**EL PASO COUNTY PLANNING AND  
 COMMUNITY DEVELOPMENT  
 DEPARTMENT**

**GRADING AND EROSION CONTROL PLAN CHECKLIST  
 Estates at Rolling Hills Ranch Filing 2**

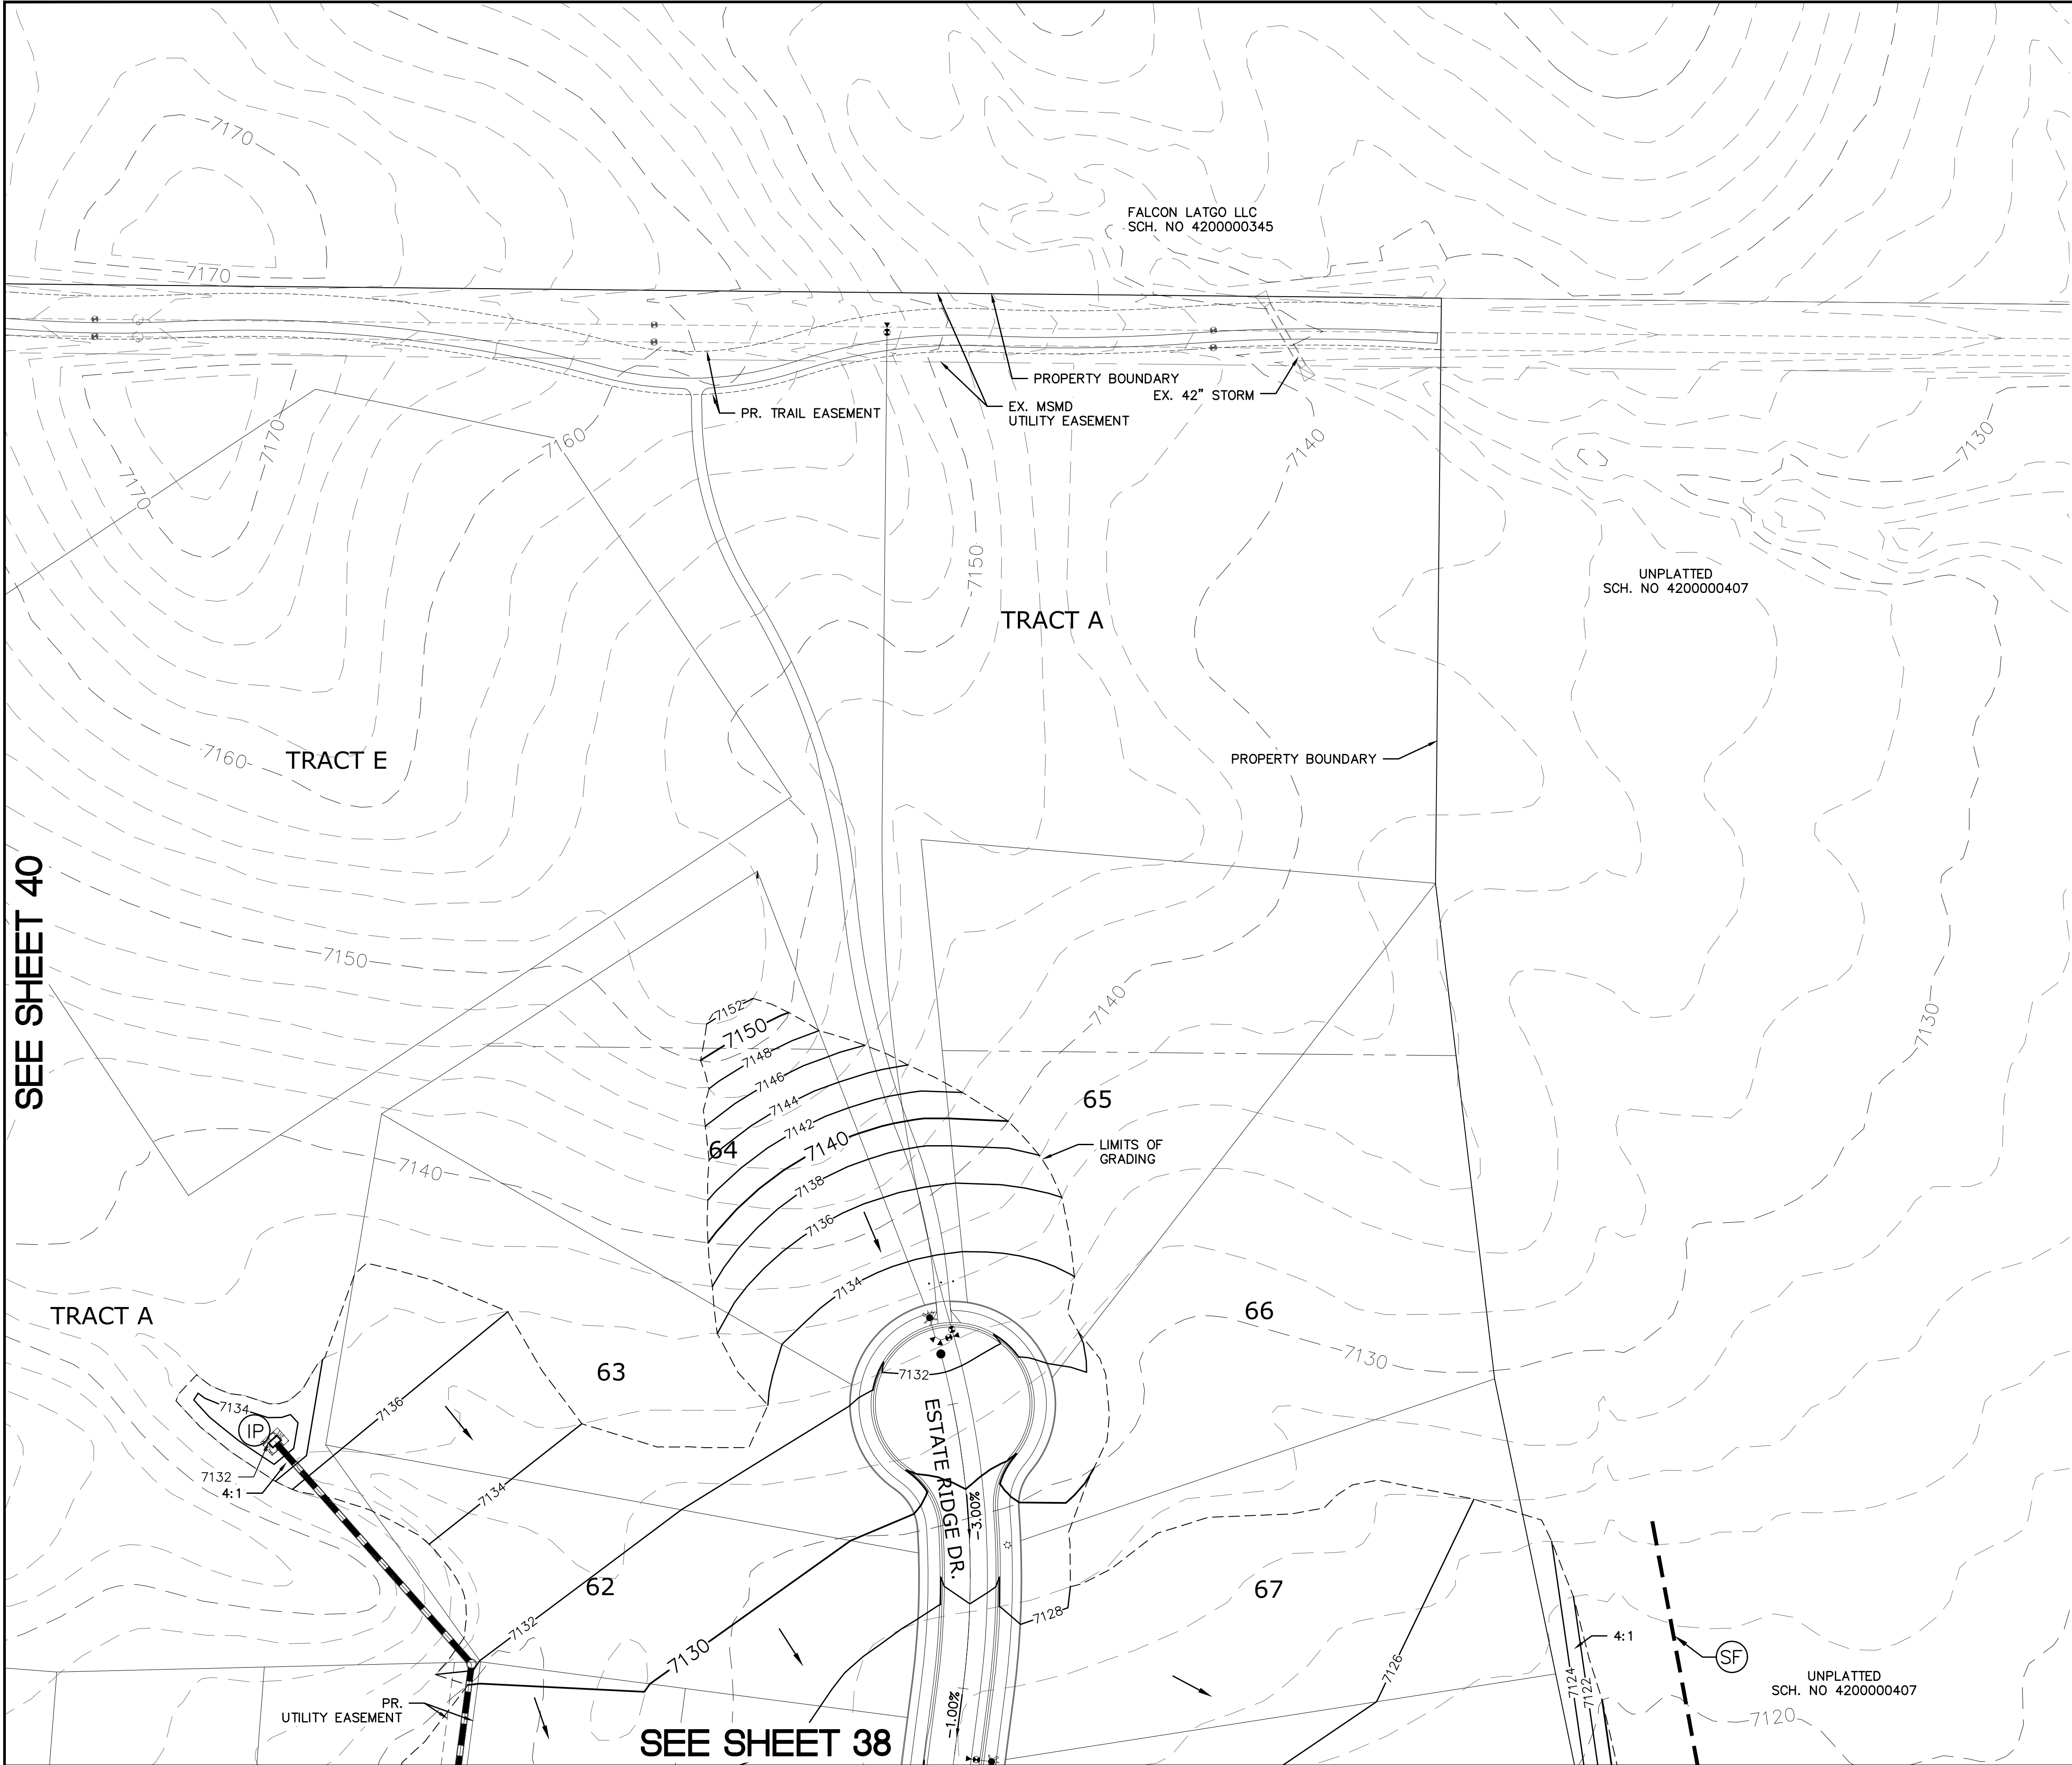
Applicant	PCD
<b>1. GRADING AND EROSION CONTROL PLAN</b>			
a	Vicinity map.	X	✓
b	Adjacent city/town/jurisdictional boundaries, subdivision names, and property parcel numbers labeled.	X	✓
c	North arrow and acceptable scale (1"=20' to 1"=100').	X	✓
d	Legend for all symbols used in the plan. Add flow direction arrows	X	X
e	Existing and proposed property lines. Proposed subdivision boundary for subdivision projects.	X	✓
f	All existing structures.	X	✓
g	All existing utilities.	X	✓
h	Construction site boundaries. See comment on GEC plans	X	X
i	Existing vegetation (notes are acceptable in cases where there is no notable vegetation, only grasses/weeds, or site has already been stripped).	X	✓
j	FEMA 100-yr floodplain.	n/a	N/A
k	Existing and proposed water courses including springs, streams, wetlands, detention ponds, stormwater quality structures, roadside ditches, irrigation ditches and other water surfaces. Show maintenance of pre-existing vegetation within 50 feet of a receiving water.	X	✓

l	Existing and proposed contours 2 feet or less (except for hillside).	X	✓
m	Limits of disturbance delineating all anticipated areas of soil disturbance. Same as Limits of Grading?	X	X
n	Identify and protect areas outside of the construction site boundary with existing fencing, construction fencing or other methods as appropriate.	n/a	N/A
o	Offsite grading clearly shown and called out.	n/a	N/A
p	Areas of cut and fill identified.	X	✓
q	Conclusions from soils/geotechnical report and geologic hazards report incorporated in grading design (slopes, embankments, materials, mitigation, etc.)	X	✓
r	Proposed slopes steeper than 3:1 with top and toe of slope delineated. Erosion control blanketing or other protective covering required.	n/a	N/A
s	Stormwater flow direction arrows.	X	✓
t	Location of any dedicated asphalt / concrete batch plants.	n/a	N/A
u	Areas used for staging, storage of building materials, soils (stockpiles) or wastes. The use of construction office trailers requires PCD permitting.	X	✓

v	All proposed temporary construction control measures, structural and non-structural. Temporary construction control measures shall be identified by phase of implementation to include "initial," "interim," and "final" or shown on separate phased maps identifying each phase.	X	X
w	Vehicle tracking provided at all construction entrances/exits. Construction fencing, barricades, and/or signage provided at access points not to be used for construction.	X	✓
x	Temporary sediment ponds provided for disturbed drainage areas greater than 1 acre.	n/a	✓
y	Dewatering operations to include locations of diversion, pump and discharge(s) as anticipated at time of design.	n/a	N/A
z	All proposed temporary construction control measure details. Custom or other jurisdiction's details used must meet or exceed EPC standards.	X	X

Sed Basins discussed as a possibility in SWMP. May be a "check" instead of "N/A" for the purposes of this checklist
